Subject	2-32 SMITH STREET, SUMMER HILL, PROJECT APPLICATION
File Ref	FM APRIL 2013
Prepared by	Con Colot - Senior Strategic Planner & Projects
Reasons	Provide the Department of Planning & Infrastructure with comments on the Project Application for Stage 1 at the Flour Mills site, 2-32 Smith Street Summer Hill.
Objective	For Council to determine its response to the project plan application.

1.0 Purpose of Report

FIGURE 7
100Y ARI DESIGN FLOOD EVENT
DEV MITIGATION CASE - IMPACTS

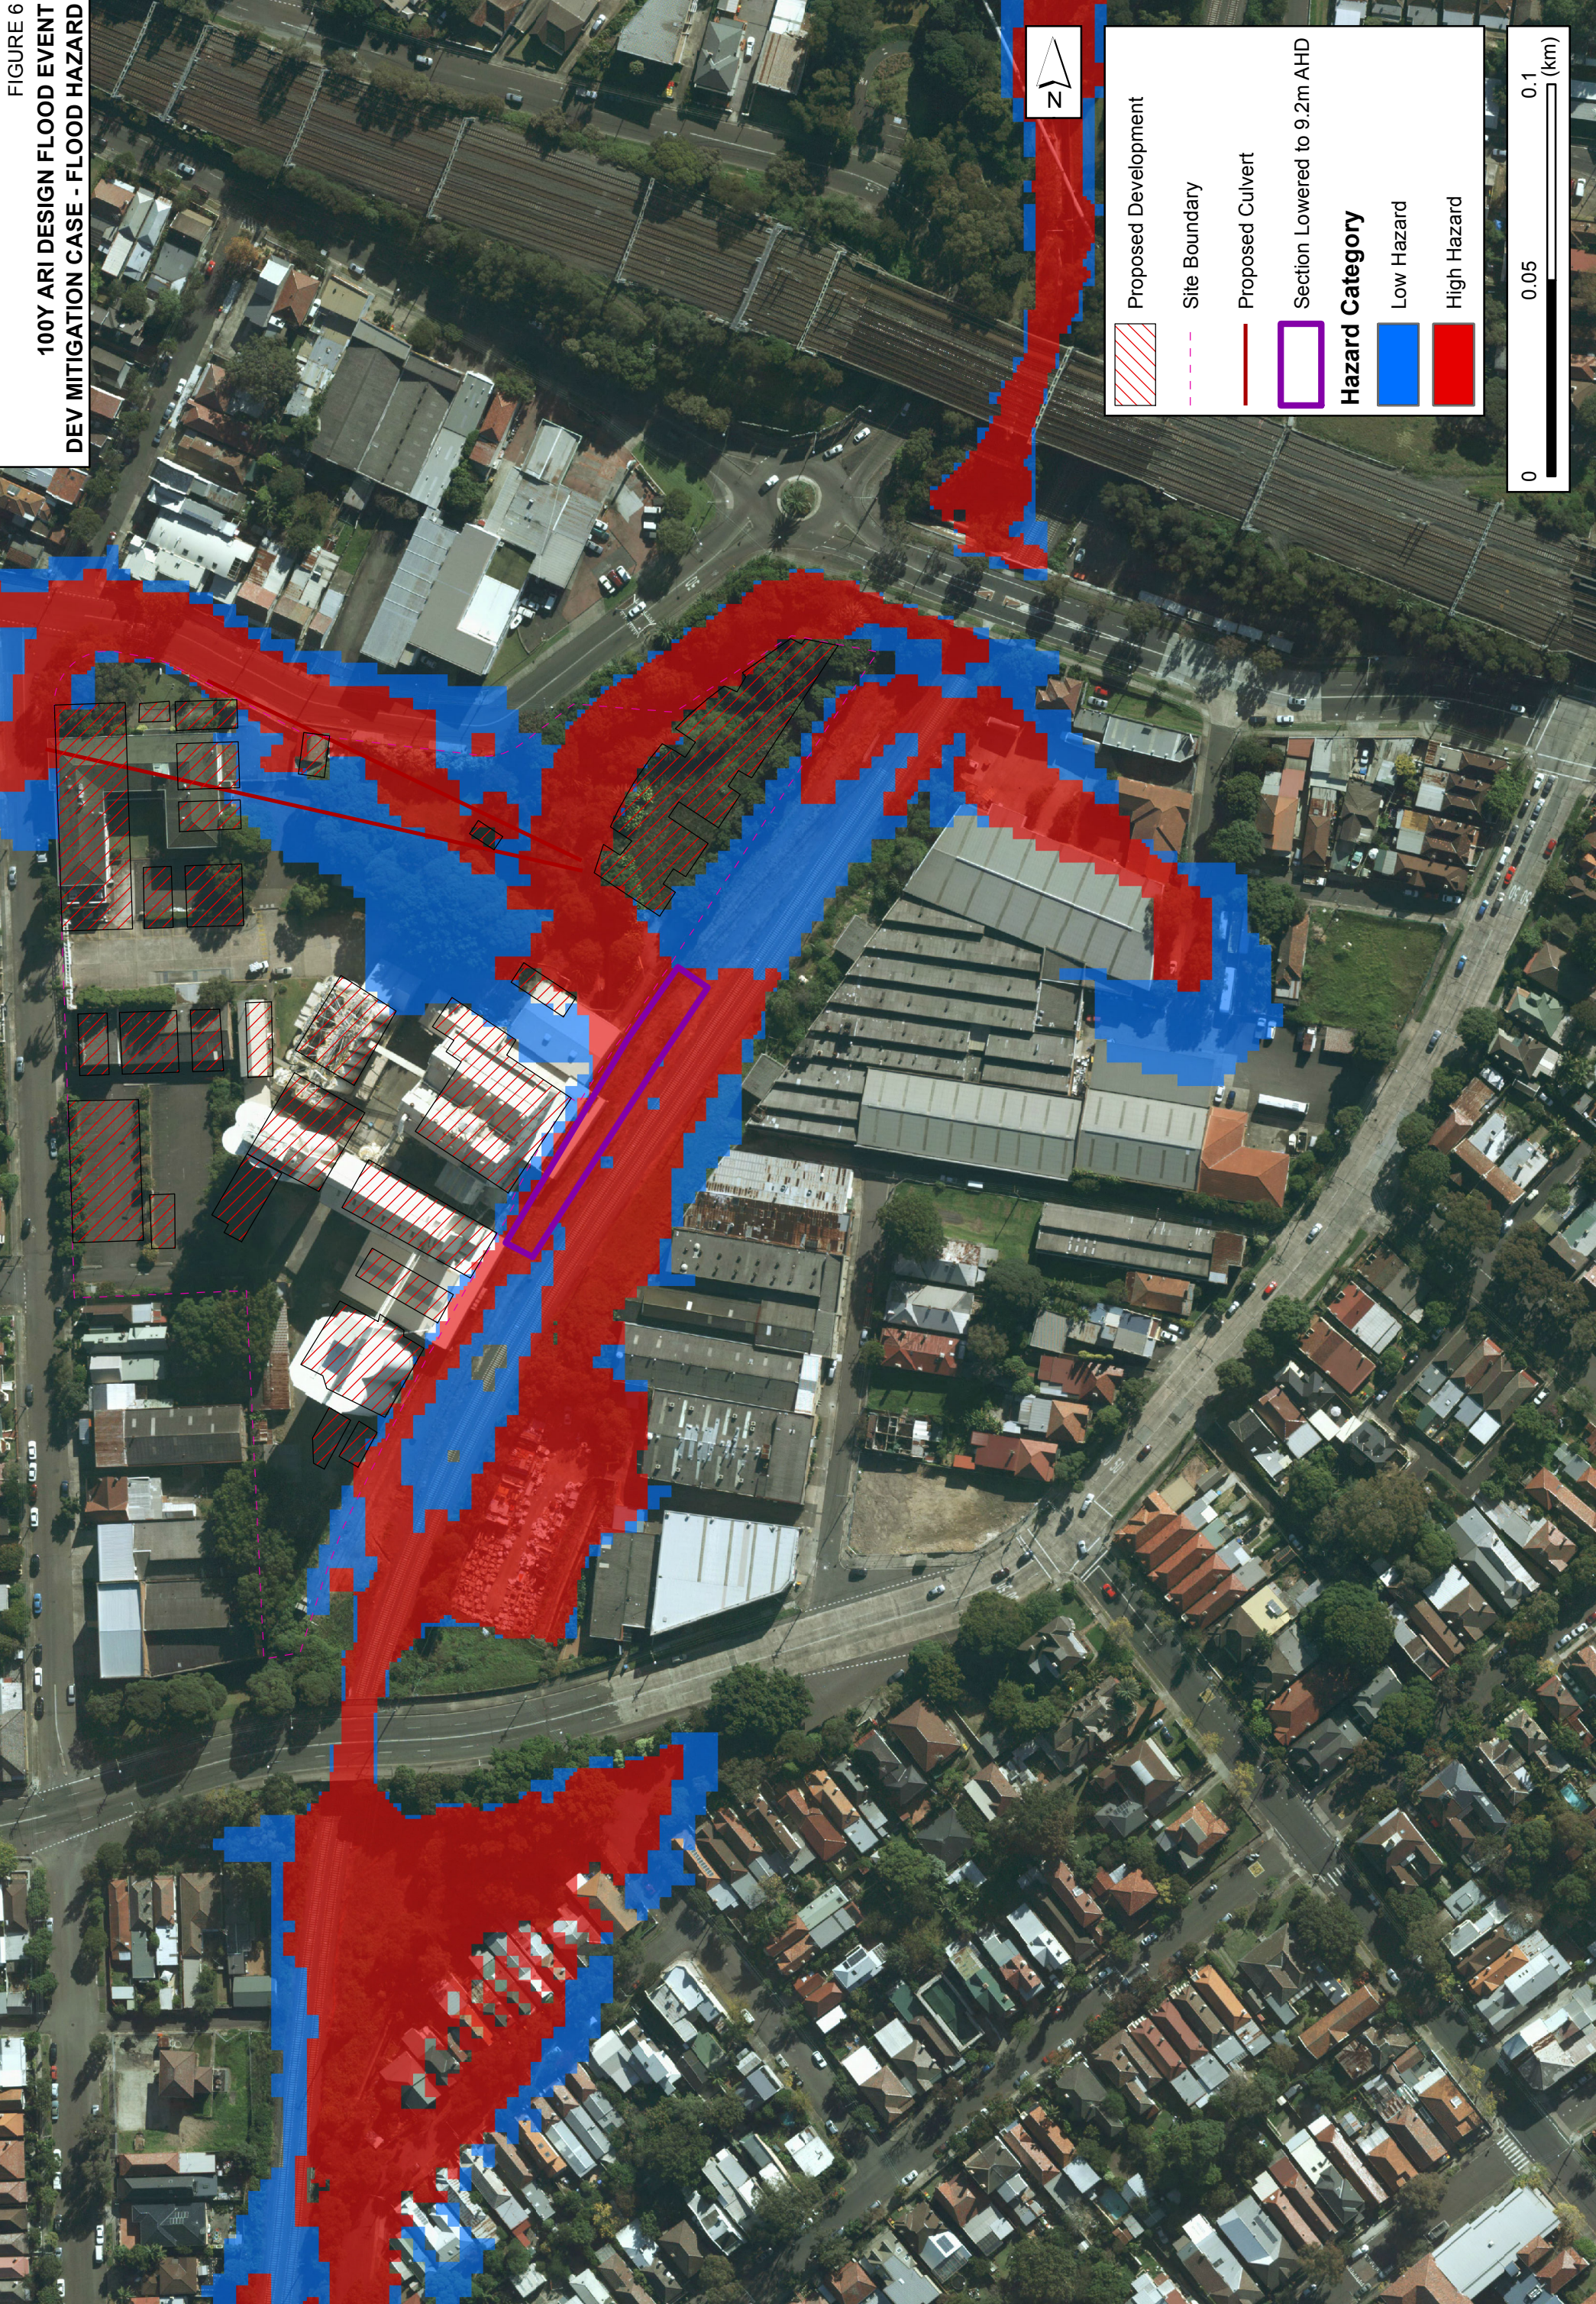
There is a large stormwater catchment area which flows down Smith Street and some of this flow is picked up by a large underground pipe from the Flour Mills site to the Hawthorne Canal - **see Diagram 3** of this report.

Some local stormwater which flows down Smith Street will be diverted around the Stage 1 site potentially down the access pathway link or within the 'Portion 4' allotment. There are various underground pipes (culverts) proposed to deal with this flow.

Council's engineers advise it is not possible at this point in time to determine whether the proposed stormwater disposal system is adequate based on the submitted documentation. Consultation between Ashfield Council would be required with Sydney Water on this matter. Additional engineering staff resources, or an independent review by consultants, would be required to analyse and check the various and numerous complexities associated with the proposed stormwater mitigation work, given the large upstream area catchment which might otherwise be adversely affected. Easements would also need to be placed on the site, which would affect the proposed subdivision plan.
